WILLOWTREE PLANNING

REF: WTJ23-225

RE: REQUEST FOR ADDITIONAL INFORMATION - CROWS NEST - OSD - SITE B (SSD-61400212)

Sheet title
COMMUNAL OPEN SPACE
ANALYSIS

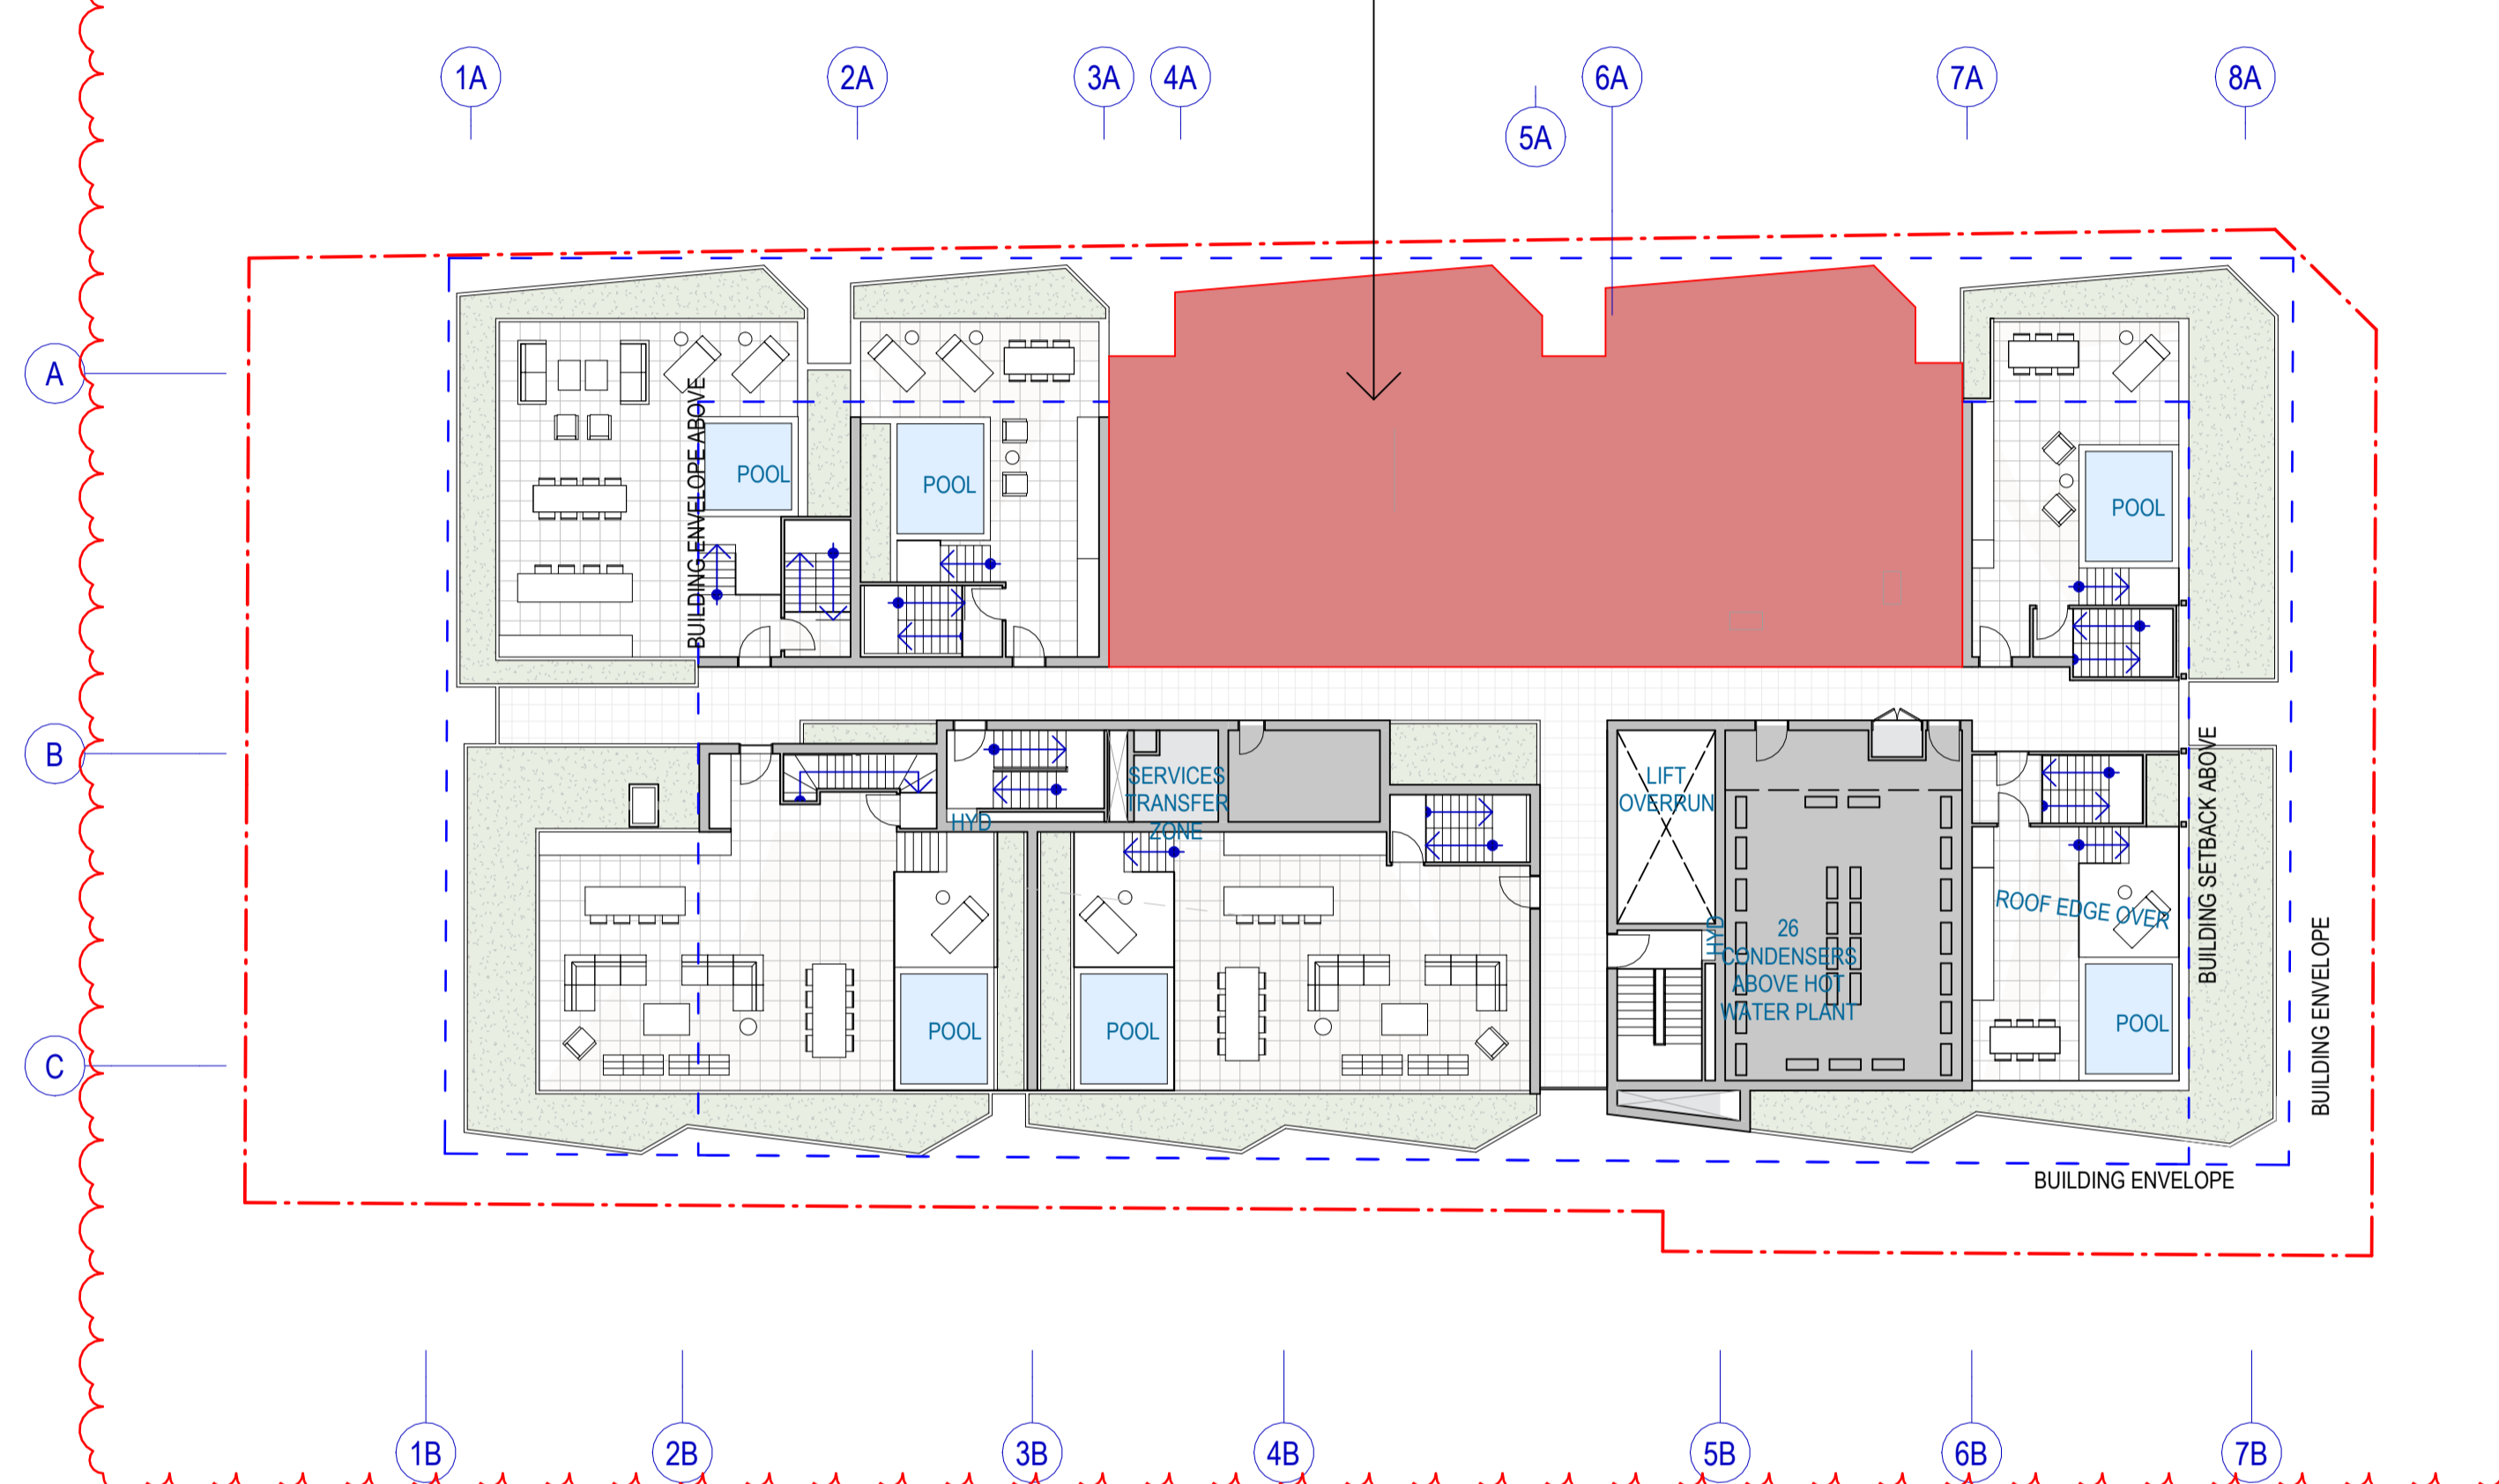
3. Communal Open Space	
Provide confirmation of communal open space.	Details of communal open space location and size are provided at Appendix 5. The proposal requires 468m² of communal open space as outlined by the ADG. The proposal achieves 400m² of communal open space. Notwithstanding this shortfall, the proposal delivers appropriate communal recreation outcomes on merit, having regard to the following considerations: • The primary communal open space provided is located at roof level where it receives excellent solar access throughout the day and offers exceptional outlook toward Sydney Harbour, maximising the quality and usability of the space for residents. • All apartments are provided with generous private open space that exceeds ADG minimum requirements, providing residents with readily accessible private recreation areas and reducing reliance on communal facilities. • The building footprint and site area has been established through the approved Concept Proposal (SSDA-9579), which limits the quantum of communal open space achievable within the detailed design phase. • The communal open space incorporates high-quality landscape design with diverse recreation opportunities including seating areas/BBQ facilities/pool/outdoor dining, maximising functionality within the available area. The proposal therefore demonstrates that while the numeric communal open space requirement is not achieved, the development delivers appropriate recreation outcomes through a combination of high-quality on-site facilities and generous private open space provision.

Sheet title  
CROSS VENTILATION

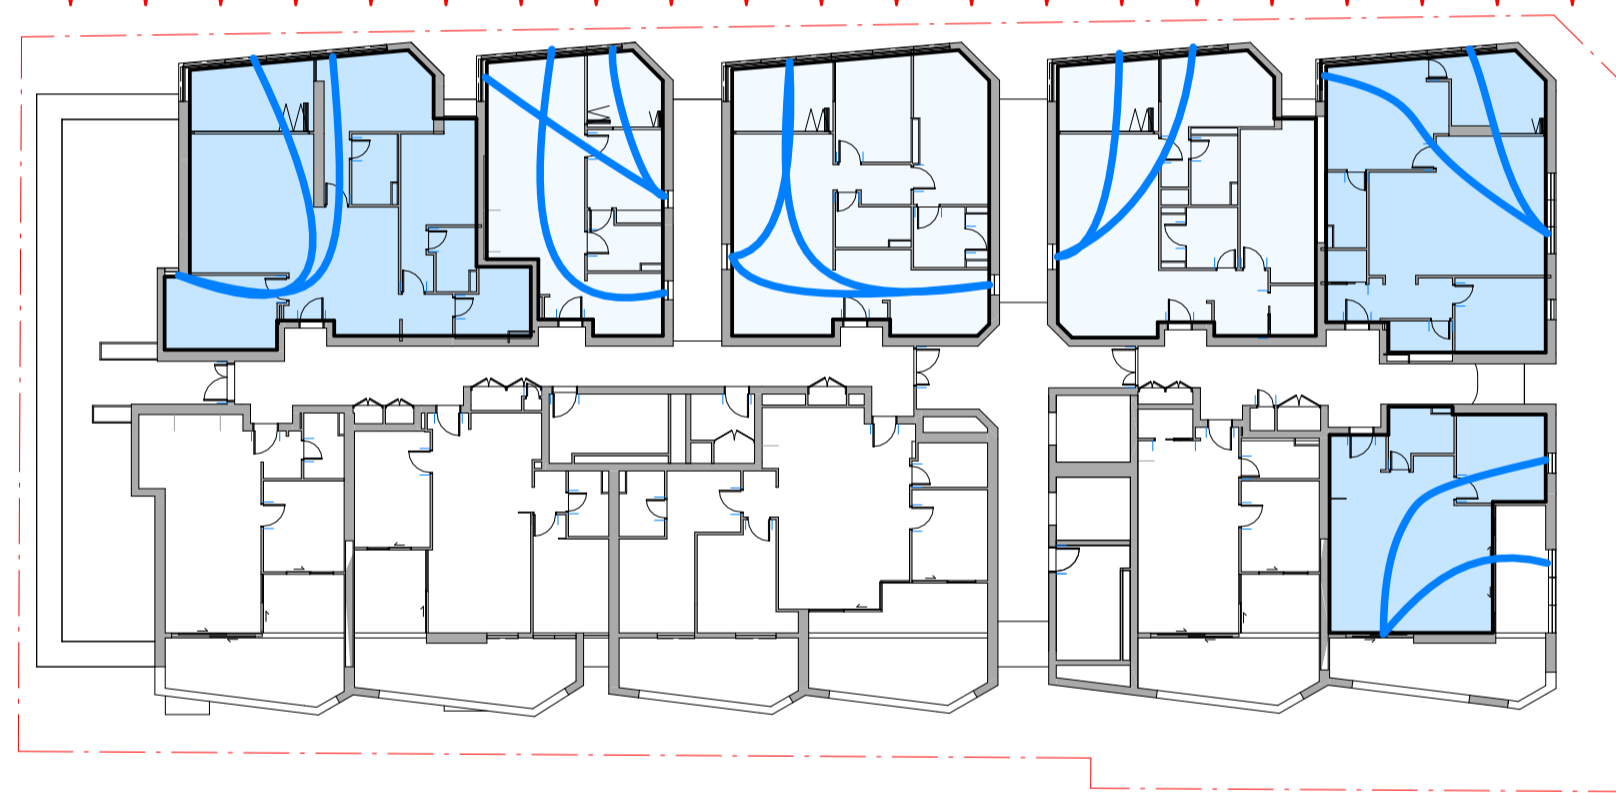
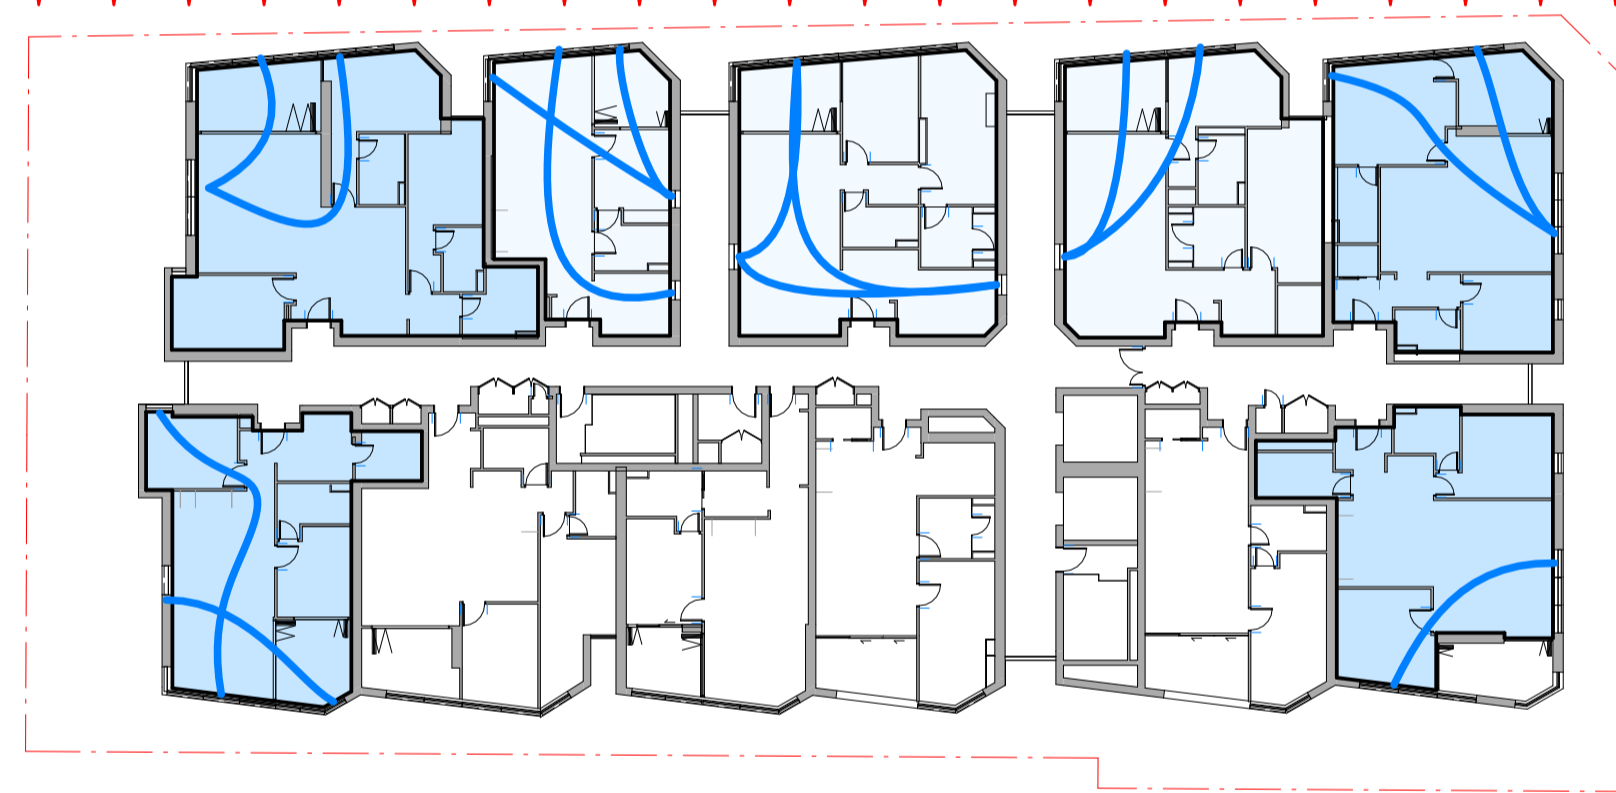
2. Cross Ventilation	
Demonstrate how the dwellings can achieve adequate natural cross-ventilation where reliant on the internal corridors, including clarifying the statement in the Acoustic Response that recommends alternative means of ventilation be provided to those dwellings on road traffic noise-affected facades.	In accordance with the Cross Ventilation drawing at Appendix 2, 34% of apartments are naturally cross ventilated within the first 9 stories of the building. Notwithstanding the numerical non-compliance with the ADG requirement for 60% of apartments to achieve cross ventilation in the first nine stories of the building, technical consideration has been provided by Arup (Appendix 3) that confirms that: <i>Given the differing wind conditions on the external façade of the site and within the corridors at any given point, depending on the wind direction, there will be pressure differentials between the various façade openings on the three apartments under review (see Figure 1 in Appendix 3). As such, these apartments have the potential to be ventilated, if occupants choose to do so.</i> Further to the above, a review of the advice from Arup has been undertaken by CPP Wind Engineering Consultants at Appendix 4 wherein it is identified that: <i>...For a relatively large building compared with the surrounds, the incident wind direction will be redirected by the building massing to induce horizontal flow along the facades. Regardless of the incident wind direction, the articulated nature of the façade would be expected to induce a pressure difference along the length of an apartment. The wind induced pressure in the deep slots would be measurably different to the façade pressures on the Pacific Highway elevation. The wind-induced pressure difference would be expected to allow the resident to naturally ventilate the apartments to meet the air quality air flow rates.</i>

<i>With the minimal pressure difference required to induce sufficient air flow to meet minimum air quality ventilation requirements, the size and location of the external openings on the articulated façade of the Level 8 and 9 apartments would be expected to meet the design intent of the ADG.</i> In accordance with the above, the combination of building massing effects, façade articulation, and pressure differentials will enable natural ventilation performance that meets the ADG's underlying air quality and amenity objectives, notwithstanding the numerical departure from the 60% cross ventilation requirement. In response to the acoustic consultant's recommendation for alternative ventilation means for dwellings on road traffic noise-affected facades, the following mechanical ventilation solution has been incorporated: • Provision of an outside air source to the intake air side of the Fan Coil Units (FCU) located in the ceiling space of each apartment, ensuring fresh air supply can be maintained with windows closed during periods of elevated traffic noise. The outside air is mixed with the return air in the return air plenum and delivered to the dwelling using the FCU fan, which operates independently of the air conditioning system to provide continuous fresh air ventilation. This system enables residents to maintain adequate indoor air quality while managing acoustic amenity, providing flexibility to utilise natural cross-ventilation when noise conditions are suitable or rely on the mechanical fresh air system when windows need to remain closed. • In addition to the above, all units will also be provided with air conditioning. In accordance with the above, the combination of natural ventilation opportunities created by building massing effects and façade articulation, together with mechanical fresh air provision for acoustically sensitive periods, ensures all dwellings can achieve adequate ventilation performance that meets the ADG's underlying air quality and amenity objectives.
